***MODIFICATION REQUEST:
Hurstville Private Hospital
37 Gloucester Road, Hurstville
(MP 11_0042 MOD 2)***

Modification to the internal layout, changes to the façade, increase in height of the lift shaft and expanded plant area on the rooftop

Secretary's Environmental Assessment Report
Section 75W of the *Environmental Planning and
Assessment Act 1979*

December 2014

1 SUN STUDY - DECEMBER 9:00 PROPOSED AND EXISTING
DA-61 Scale: 1:500

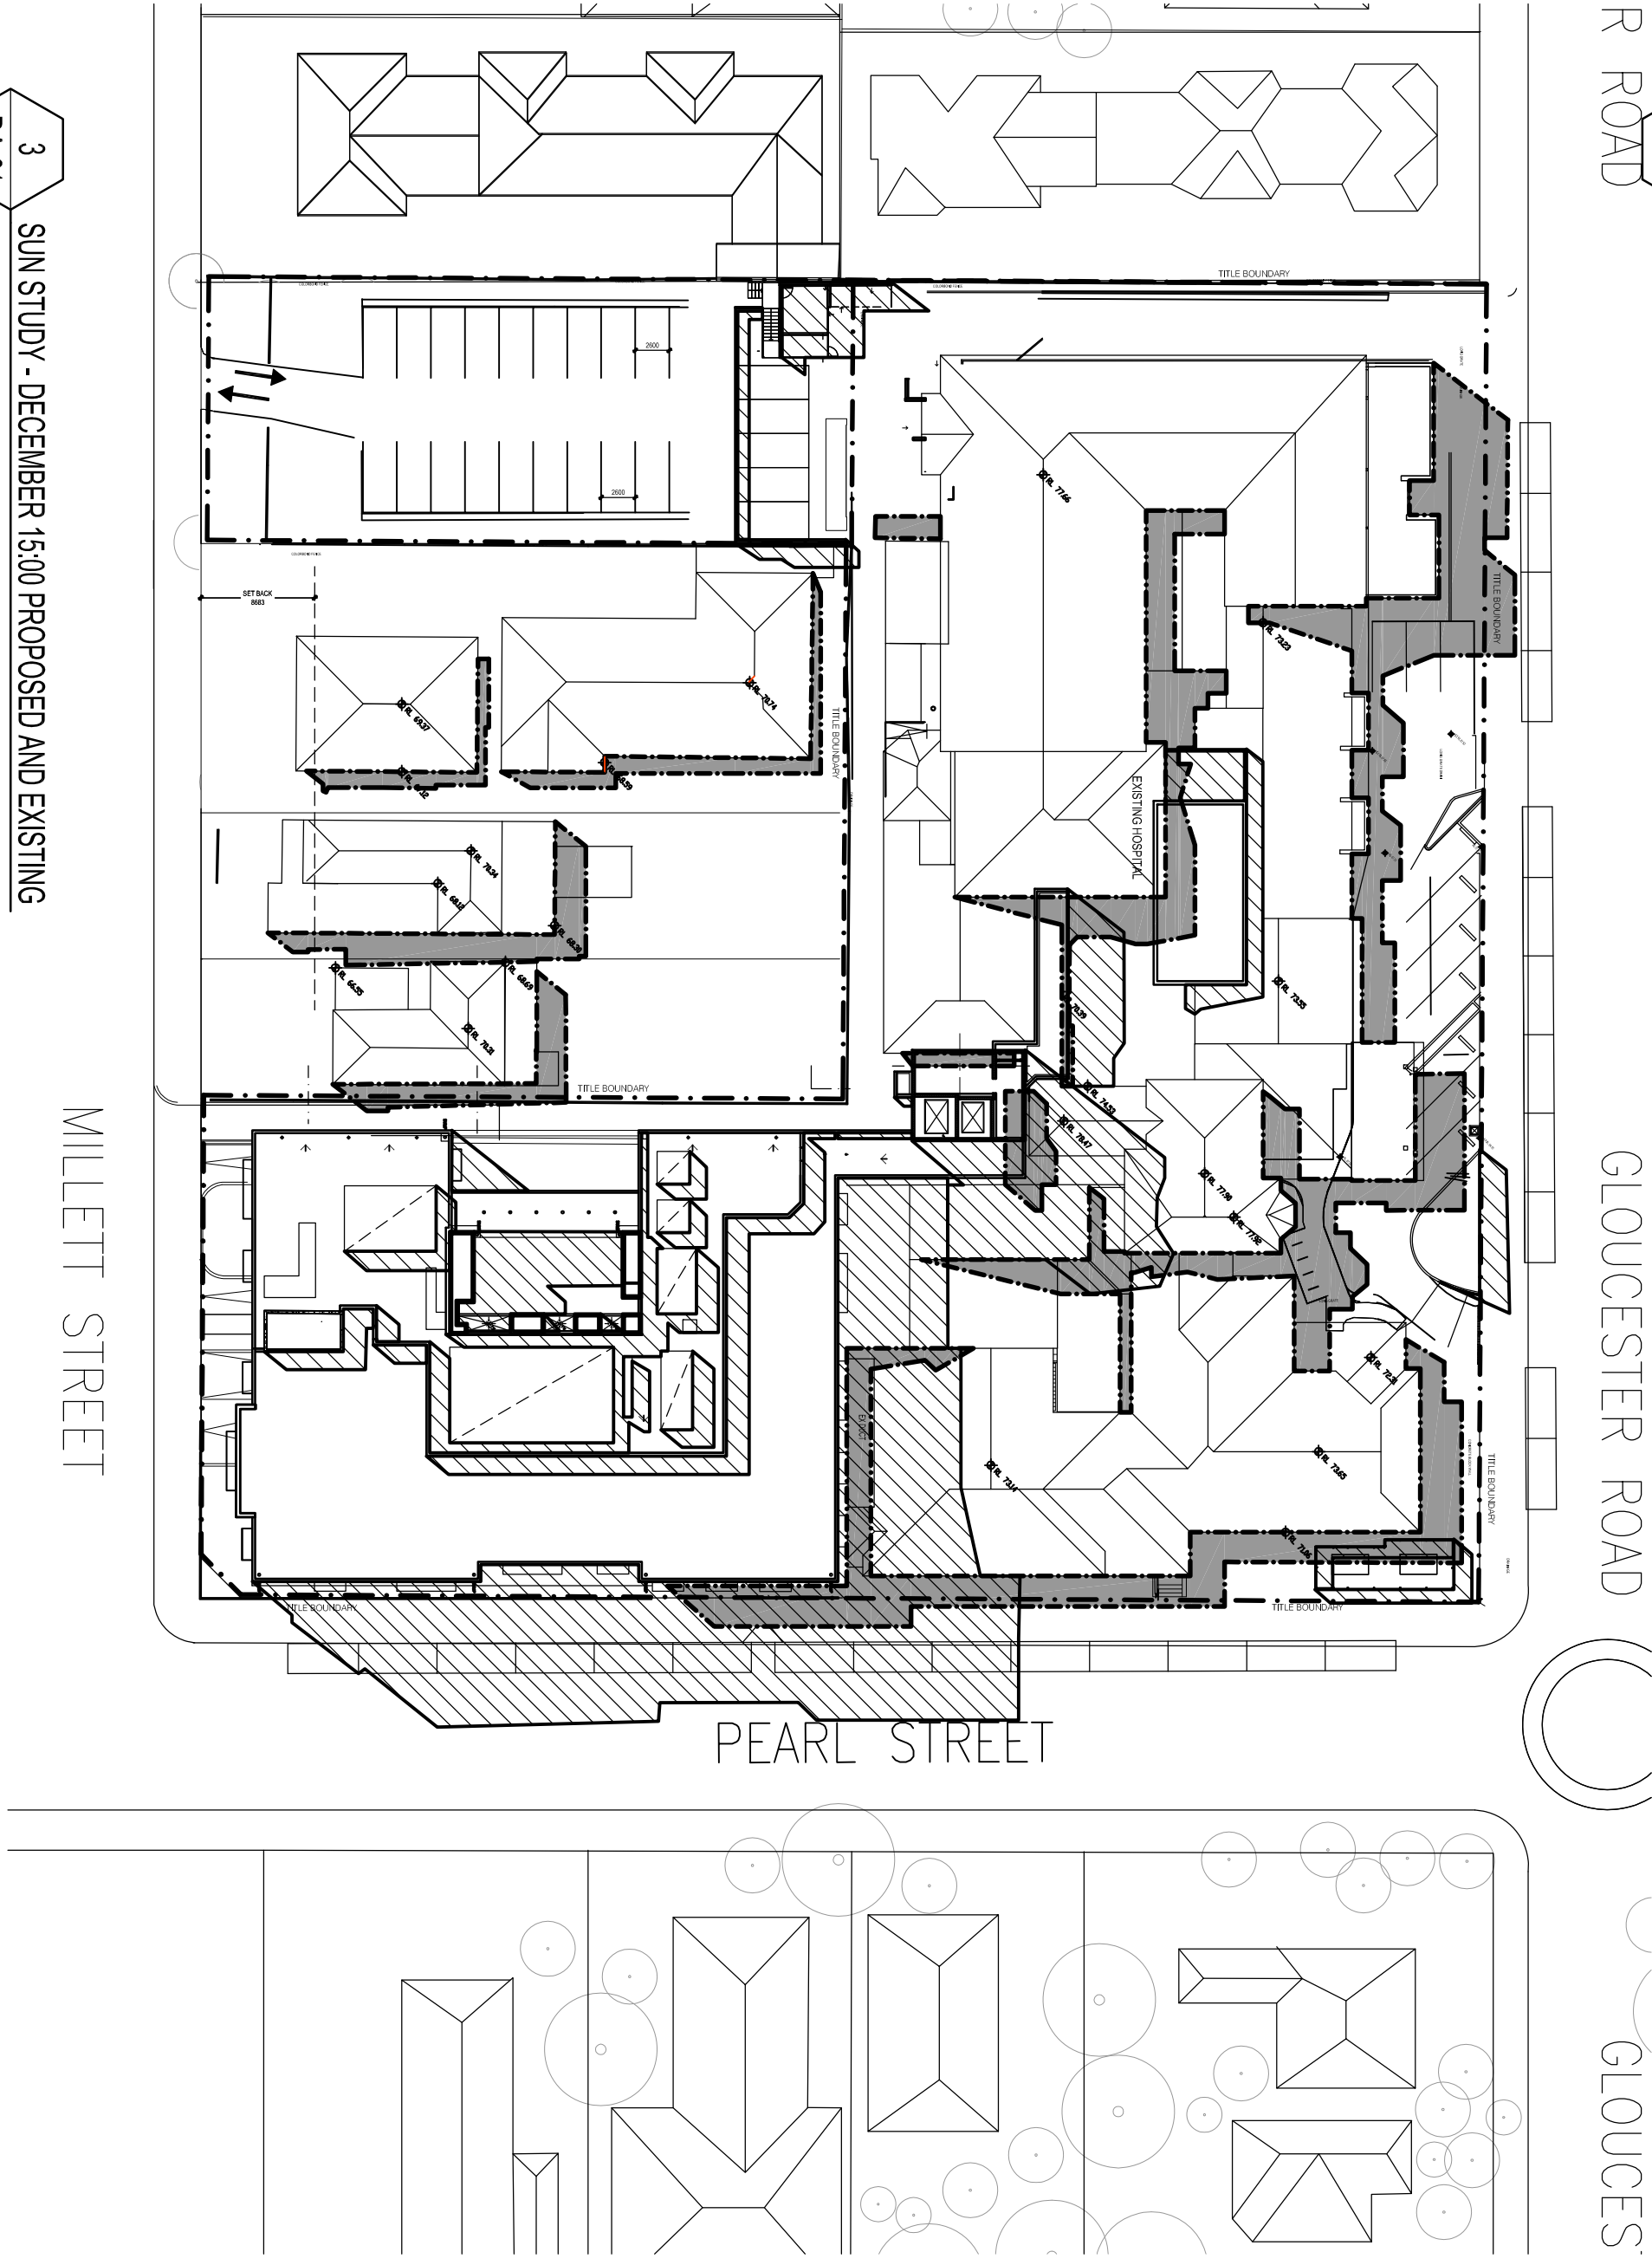
The additional height associated with the lift core also has the potential to adversely impact on the amenity currently enjoyed by the adjoining low scale residential properties directly to the south-west, fronting onto Millett Street. The proposed additional height would be readily visible above the parapet of the main building from these properties. However, the additional height would be offset by the removal of the link-way at the base of the lift core (as a consequence of the link corridor being relocated to the Gloucester Road side of the core), which would introduce a more slender building form (see **Figure 4**). The additional height associated with the lift overrun would also introduce some articulation to the roof line and assist in breaking up the mass of the building when viewed from the rear of the adjacent residential properties. Shadow diagrams submitted with the modification application demonstrate that there will be negligible additional shadow impacts on the rear of residential properties in Millett Street.

TITLE:
PROPOSED ROOF PLAN

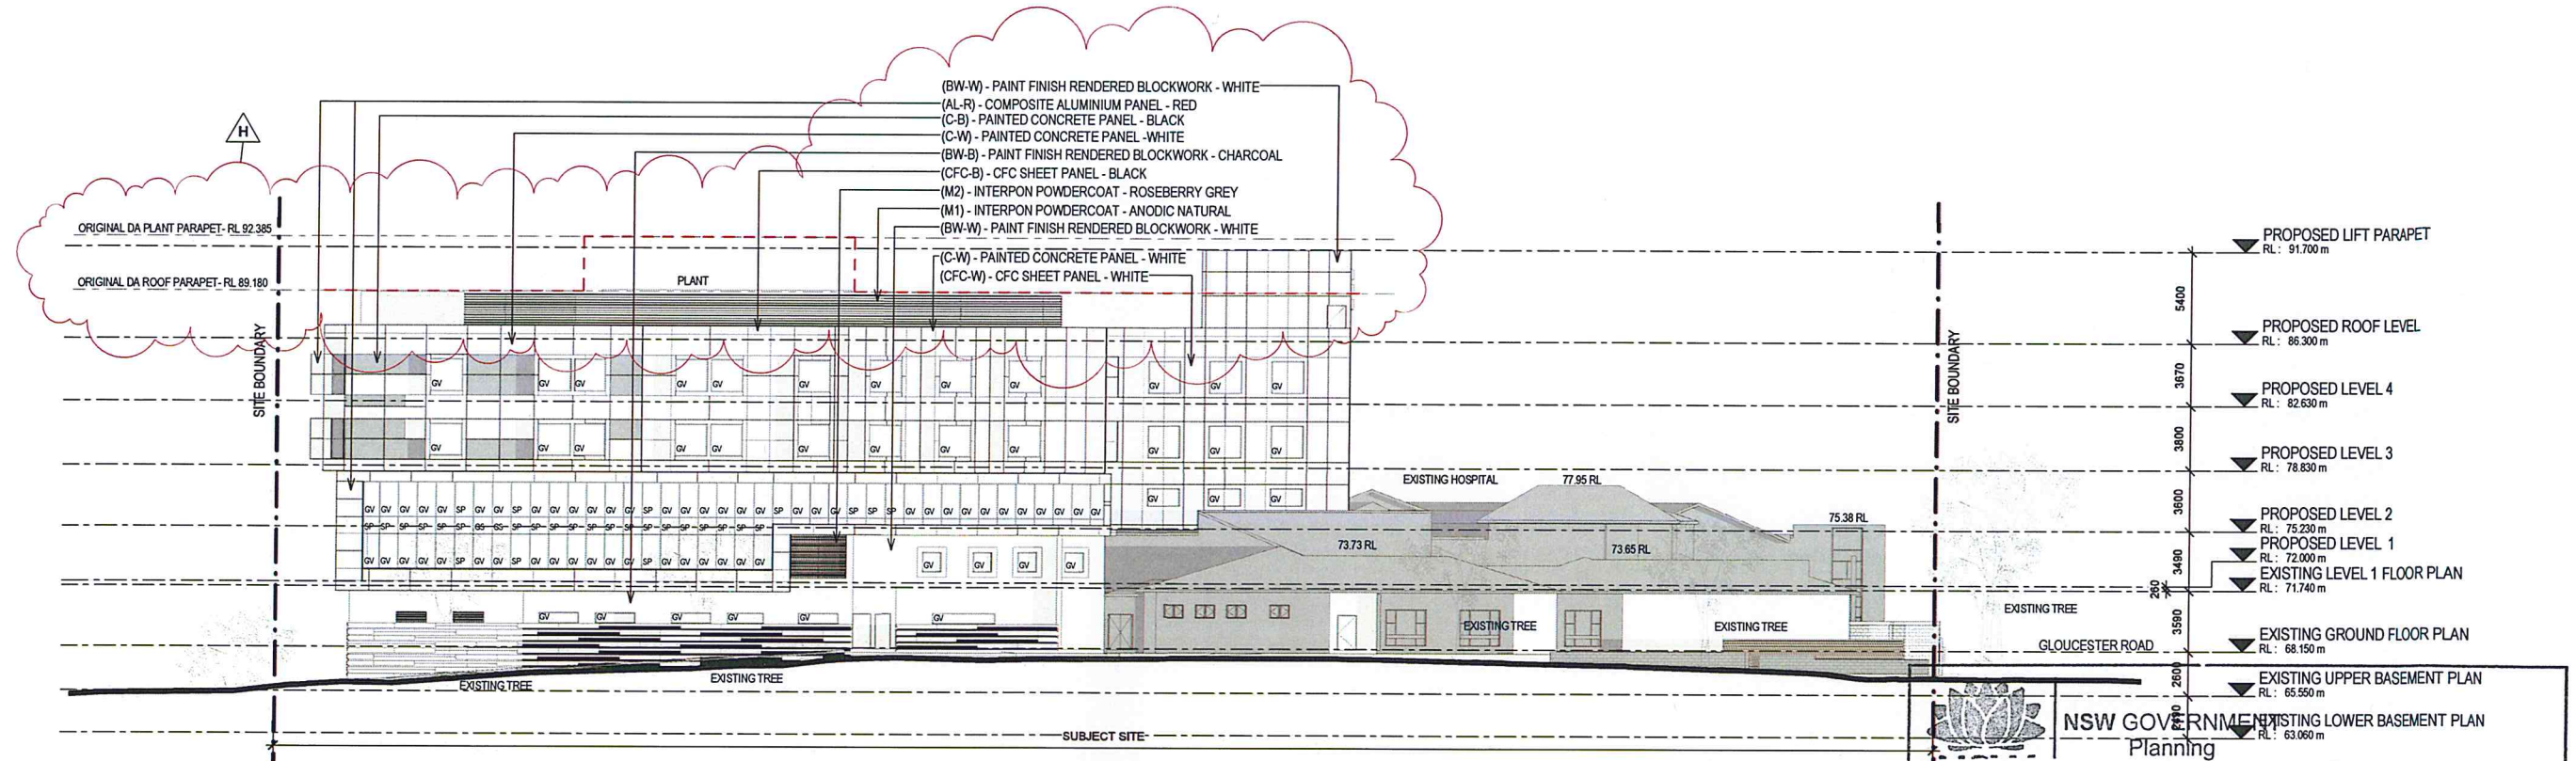
The proposed modification also seeks to expand the footprint of the mechanical plant on the rooftop (see **Figure 2**) which would add to the height and bulk of the main hospital building when viewed from the west. The previous modification application (MOD 1) approved the removal of an entire floor from the main hospital building, resulting in a corresponding reduction in height by approximately 2 m compared to the originally approved development application. The additional plant area proposed in this modification application would be contained within the originally approved building envelope, and there would be no additional visual or amenity impacts to adjoining properties beyond that which has already been assessed as reasonable in the originally approved application (refer to **Figure 5**). The Department therefore concludes that the additional bulk and height associated with the expanded footprint of the plant area to be acceptable.

The proposed expansion of the plant area on the rooftop is required to meet the specific requirements of the hospital identified during the detailed design of the project. The proponent has advised that the plant area has now been spread out and wrapped around the void on the rooftop. The acoustic assessment which forms part of the approved application includes specific noise criteria to be complied with to control noise emitted by mechanical plant. The Department is satisfied the mechanical plant on the rooftop would be appropriately treated to comply with the noise condition on the approval and mitigate potential noise impacts to the adjoining residential properties.
